## REFUSAL OF PLANNING PERMISSION

APPLICATION NO. 2019/0921

**Proposal** Erection of 2 no. flats within a new two storey building (Outline seeking approval over layout)

**At** 11A Park Grove, Barnsley, S70 1PY

Site Plan
Scale 1:200

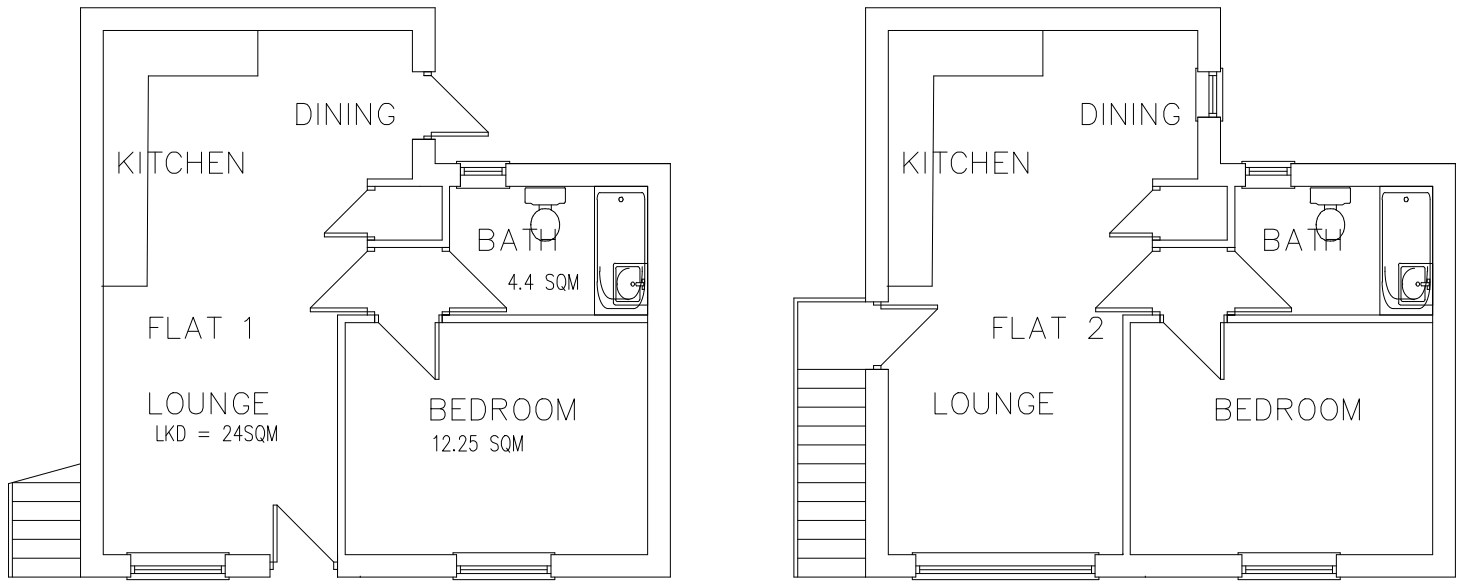
- 1 In the opinion of the Local Planning Authority the proposed development would represent an unacceptable form of backland development which would not be in keeping with the character of the surrounding area, would not integrate with the existing street scene and would appear cramped and incongruous in the context of its surroundings. Consequently the proposal is contrary to Local Plan Policy D1 and the Supplementary Planning Document (SPD) - Design of Housing Development.

- 2 The proposed building would fail to meet the minimum separation distance of 21m between rear habitable rooms and the minimum 10m to the boundaries of the adjacent private rear garden areas as set out in the Designing New Housing Development SPD. As such, the close relationship to adjacent dwellings and their habitable room windows would harm privacy for existing residents by an unacceptable degree and would mean that the future residents of the flats would suffer from substandard privacy and aspect. The proposal is therefore contrary to Local Plan policies GD1 'General Development', D1 'High Quality Design and Place Making' and the Design of Housing Development SPD.

- 3 In the opinion of the Local Planning Authority the proposal fails to provide adequate levels of off street parking, resulting in an increased demand for off street parking in an area where on street parking space is already oversubscribed. This would result in further obstructions to the free and safe flow of traffic which would be detrimental to highway safety. The proposal is therefore contrary to Local Plan Policy T4 New Development and Transport Safety and the Council's Parking Supplementary Planning Document.

- 4 In the opinion of the Local Planning Authority, the proposed development would fail to deliver the adequate standards of amenity for future residents by virtue of them not being large enough to satisfy the minimum internal space standards set out in the South Yorkshire Residential Design Guidance, poor outlook and natural daylight levels into the habitable rooms at ground floor level. The proposal is therefore contrary to Local Plan policies GD1 'General Development', D1 'High Quality Design and Place Making' and the Design of New Housing Development SPD.
